Recommendation Report for Planning Permission for Works or Extension to a Dwelling

REF NO: P/131/21/HH

LOCATION: 114 Harbour View Road
Pagham
PO21 4RJ

PROPOSAL: Single storey rear extension and 2 x side dormers

Proposed Ground Floor Plan

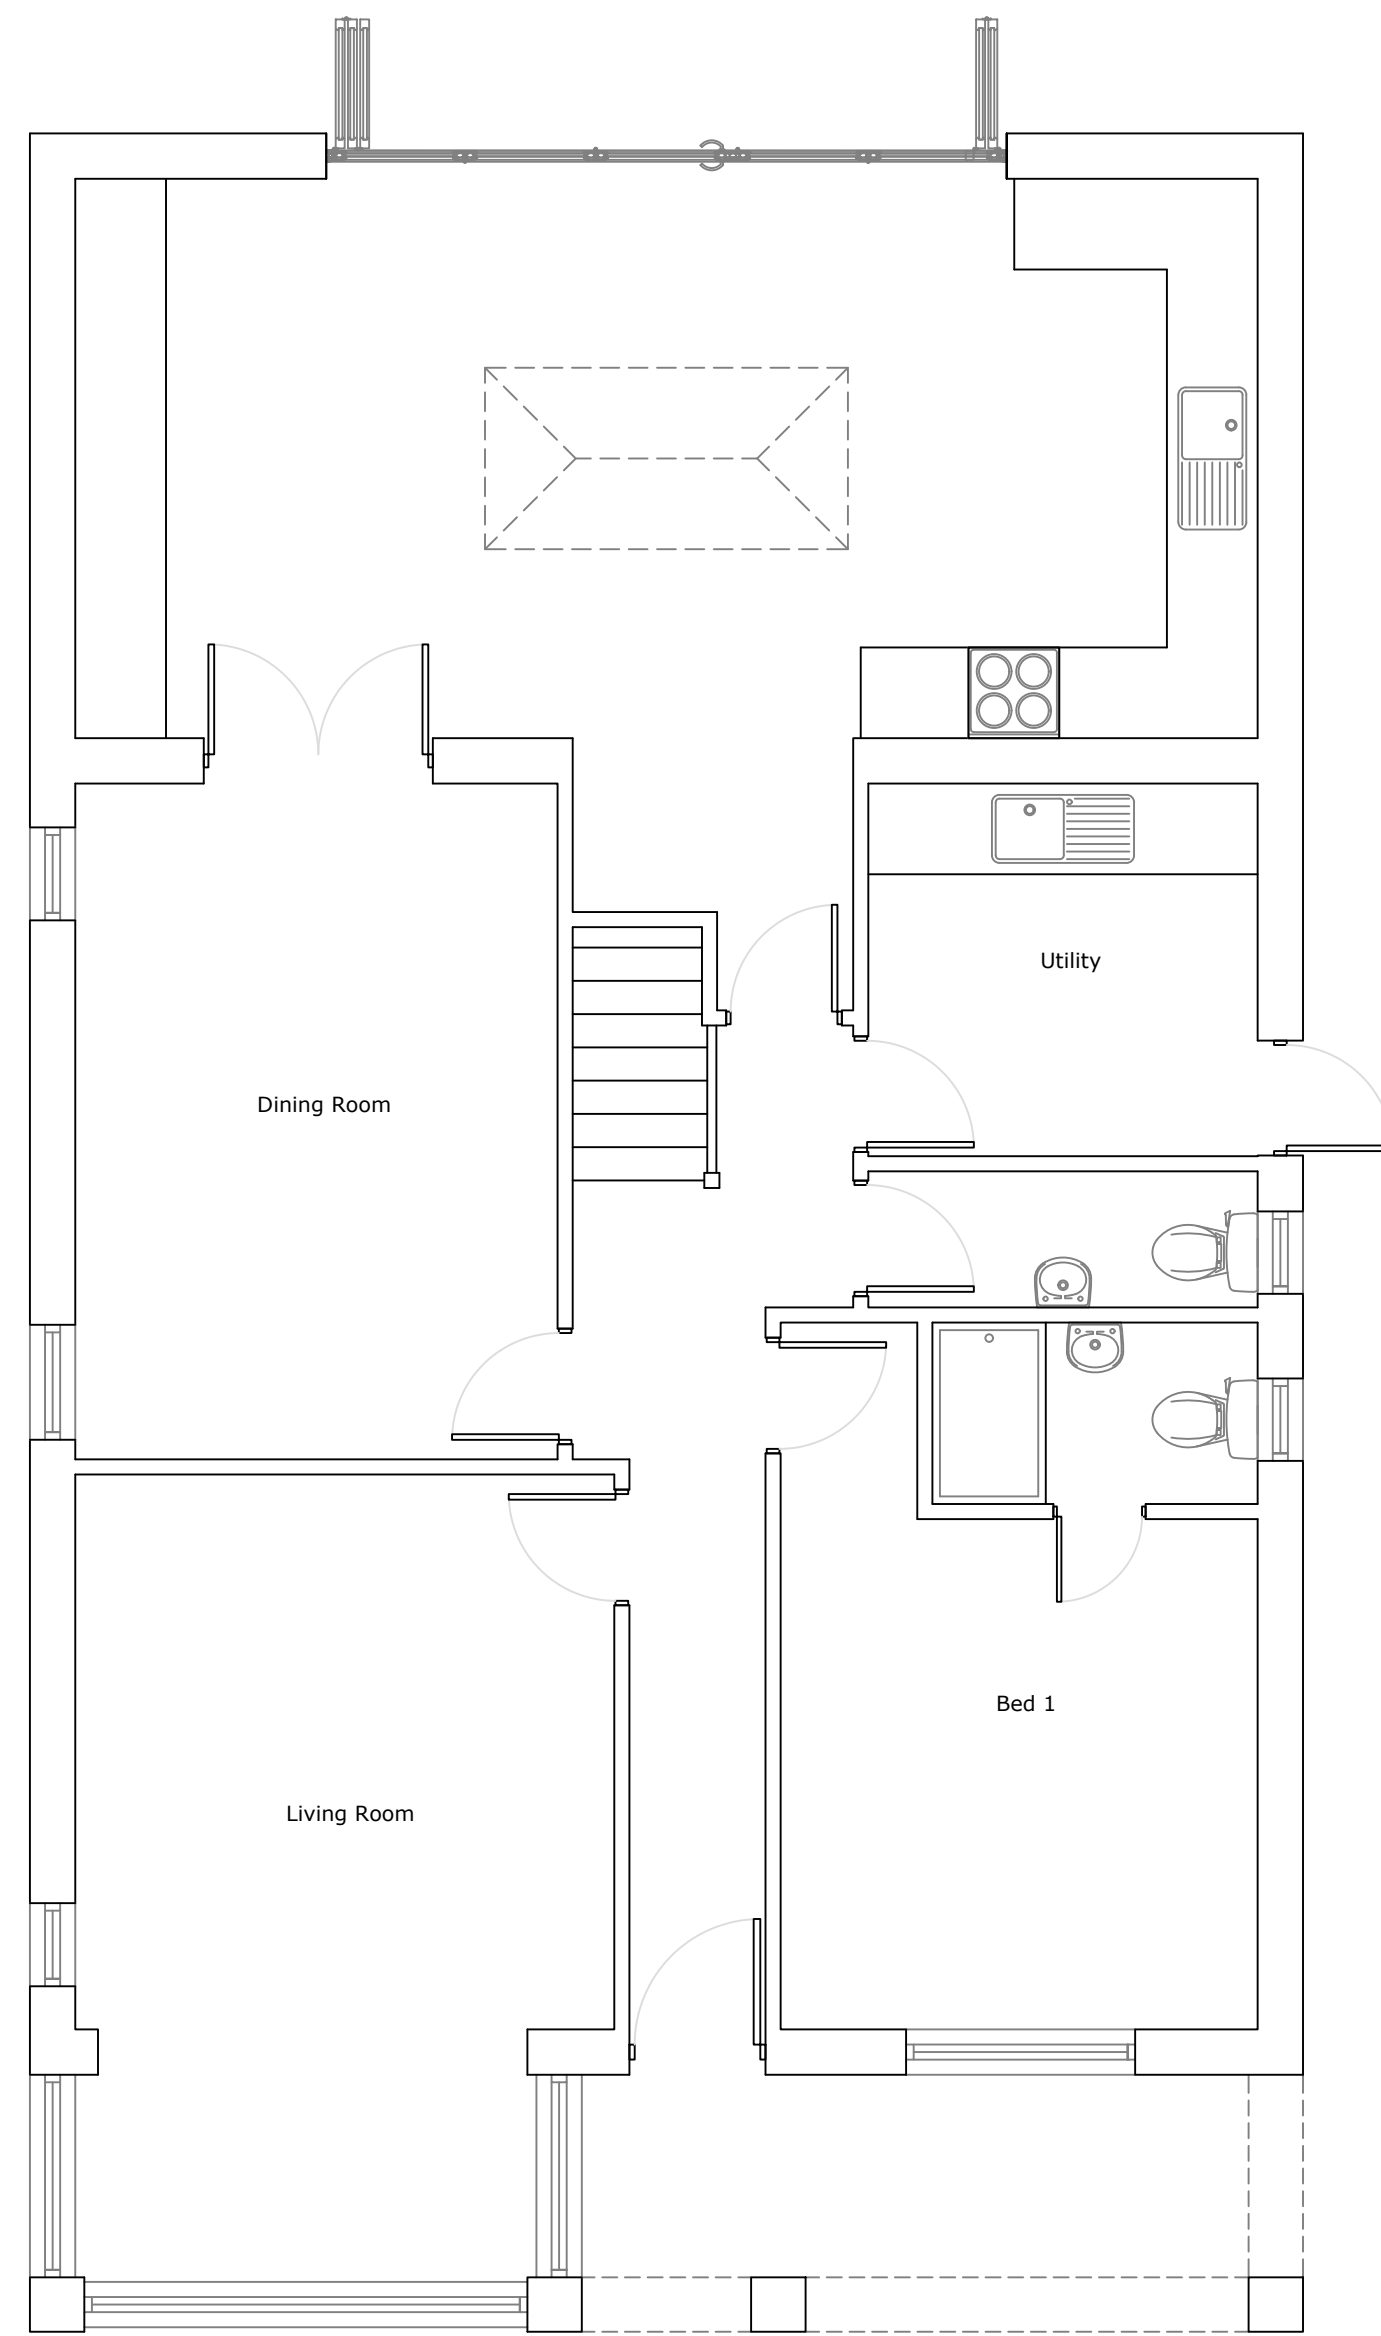
The proposed single storey extension will be sited to the rear and will infill the rear principal (west) elevation. Due to the siting of extension to rear (west) it will not be visible from the street scene so will not harm surrounding character of area so will comply with policy D DM1 of the Arun Local Plan.

The proposed rear extension will have a width of approximately 8.43m and a depth of approximately 4.14m. The height to top of flat roof will be approximately 2.87m and to top of roof light will be approximately 3.44m. There will be a gap of 2.78m retained to the north, 0.71m to the south and 14.41m to the rear (west) boundary. There will be new French doors (5 panes) to rear (west) and one new roof lantern light.

There will also be works to the front (east) ground floor to extend living room forwards within existing

porch area. The existing open porch area to front will be part converted into a closed area with a new wall to ground floor front (east) principal elevation containing a new window (6 window panes) facing front driveway.

The new closed porch area to front (east) will also contain one new window (2 window panes) to north elevation and one new window (2 window panes) to south elevation at ground floor.

The existing central door to ground floor south elevation will also be blocked up and replaced with a new window to south.

Proposed First Floor Plan

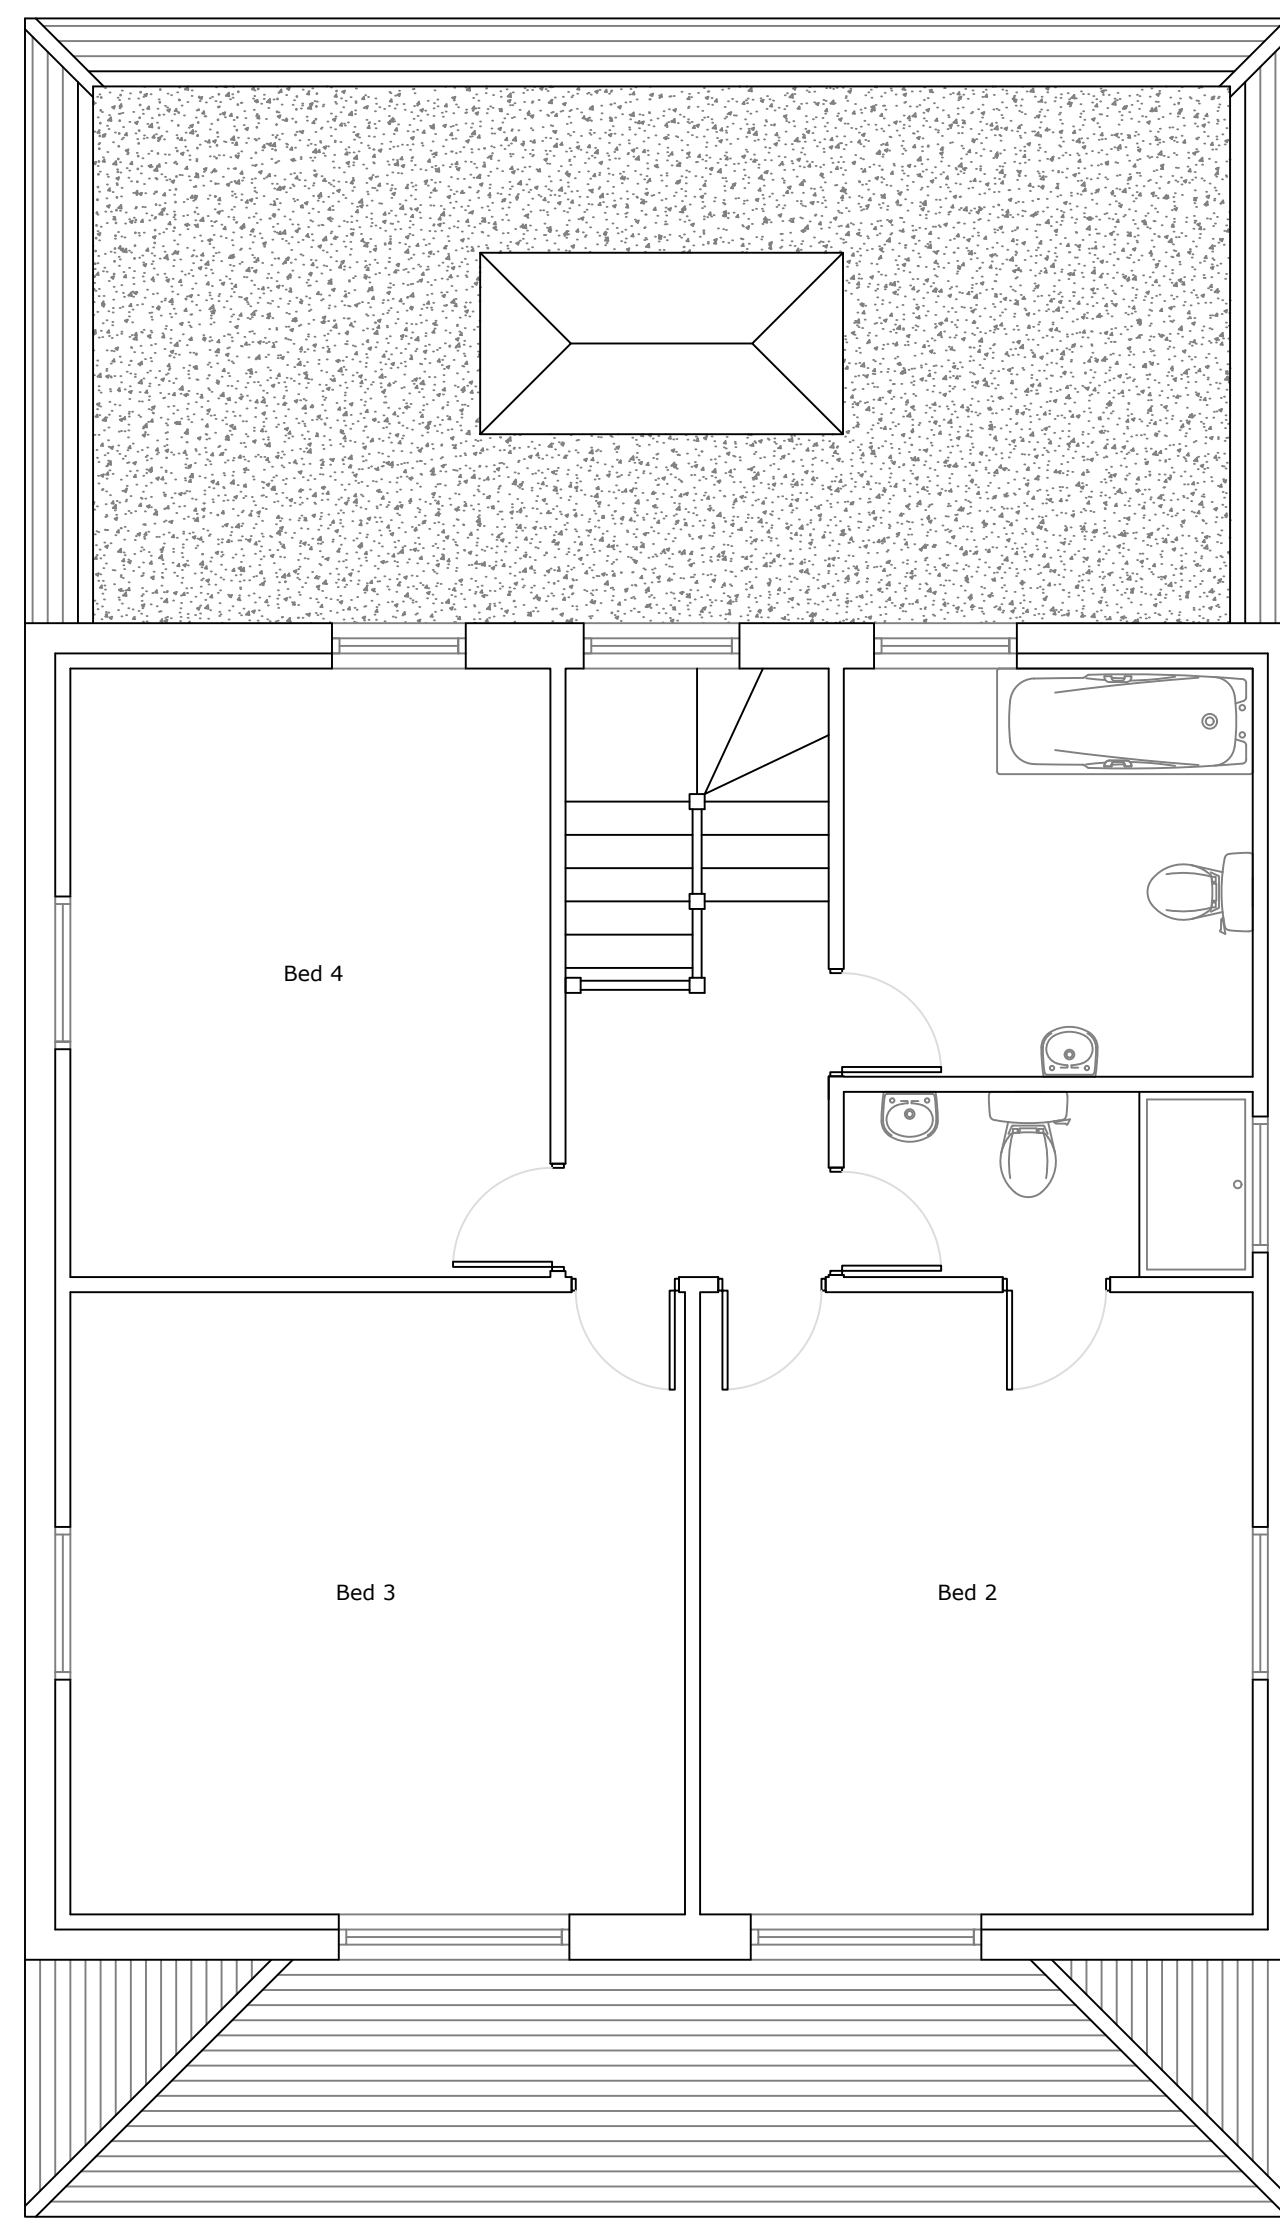
The 2 x side dormers will be sited to the north and south roof planes. Due to siting to sides they will be highly visible from street scene. The dormers large flat roofed designs are not in-keeping with surrounding properties and are large additions to the existing property. The surrounding properties to front (east) are single storey bungalows, to the south is a larger two storey dwelling and there is only one small dormer to neighbouring property number 112 to north so the proposals are out of character within area. However they could be done under Permitted Development dependent on the size and materials used so are acceptable.

The dormers will be approximately 8.75m wide x 2.61m high x 2.36m deep. They will each contain 2 windows (2 window panes each). The dormers will add additional space to the 3 bedrooms and bathroom at first floor.

The new dormer to north side roof plane will increase risk of overlooking to neighbouring property number 112 to north. However No. 112's small pitched roof dormer to south is glazed at first floor so there is no harm caused and a condition will be required to glaze the new bathroom window of the

dormer to reduce overlooking impact to No. 112's Velux window. There is also risk to overlooking to 112's ground floor living / kitchen window however due to glazing of the new dormer's bathroom window and the new bedroom window being sited further forward (east) there is reduced direct overlooking to No. 112's ground floor so is acceptable.

The new dormer to south side roof plane will not cause adverse harm to overlooking to neighbouring property number 116 to south due to the dormer window facing the roof plane of No. 116 opposite. There is slight increased risk to overlooking to neighbouring property No. 116's first floor window facing north however due to angle of dormer, the line of sight from new dormer will not cause adverse overlooking impact to warrant a refusal so is acceptable.

Reason: To comply with Section 91 of the Town and Country Planning Act 1990 (as amended).
- 2 The windows on the north side dormer bathroom window of the building at first floor level shall at all times be glazed with obscured glass and be fixed to be permanently non-opening unless the parts of the window which can be opened are more than 1.7 metres above the floor of the room in which the window is installed.
